KIRKLEES METROPOLITAN COUNCIL INVESTMENT & REGENERATION SERVICE

DELEGATED DECISION TO DETERMINE PLANNING APPLICATIONS

Reference No:	2024/62/90293/W
Site Address:	2, Bank End Knoll, Oakes Lane, Brockholes, Holmfirth, HD9 7BF
Description:	Conversion of garages to living space, internal alterations, installation of gate and replacement windows and doors
Recommending Officer:	Tom Hunt

Officer Report

Proposed Gate Detail

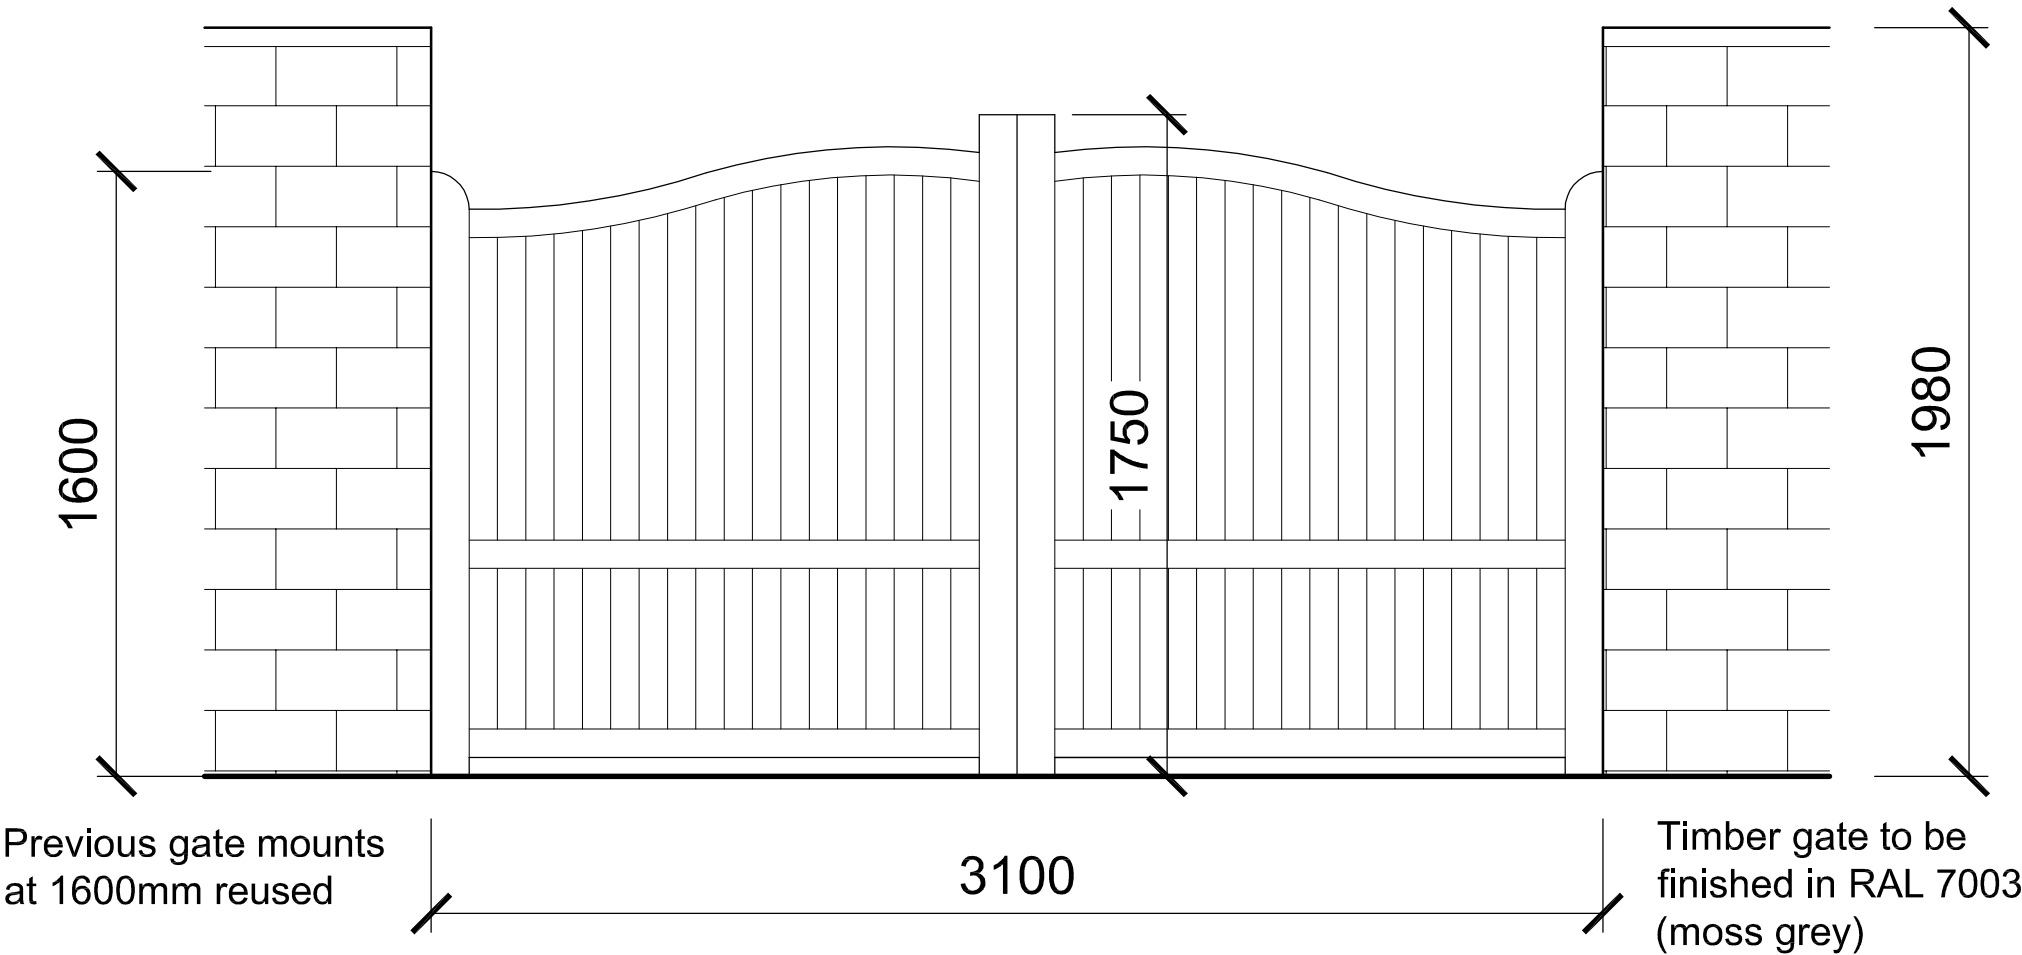
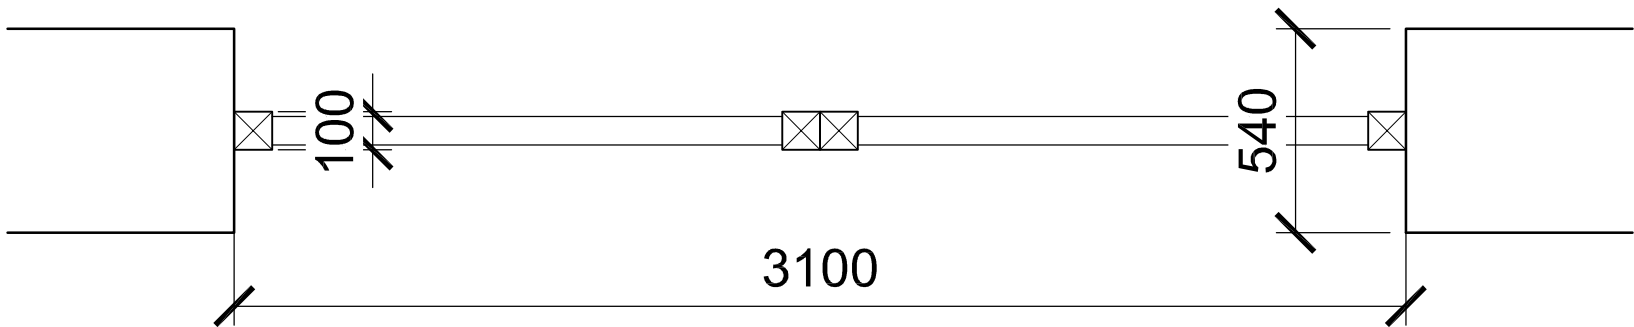
Within the site, it is proposed to supply 4 parking spaces and to have newly gated access. The automated gates would make reuse of the previous gate mounts, be in timber close boarded design finished in RAL 7003 (moss grey) and an overall height of 1.75m.

The gated access would be set back sufficiently from the highway on an existing driveway so as to not require a condition to have this opening inwardly to prevent impedance to the public highway.
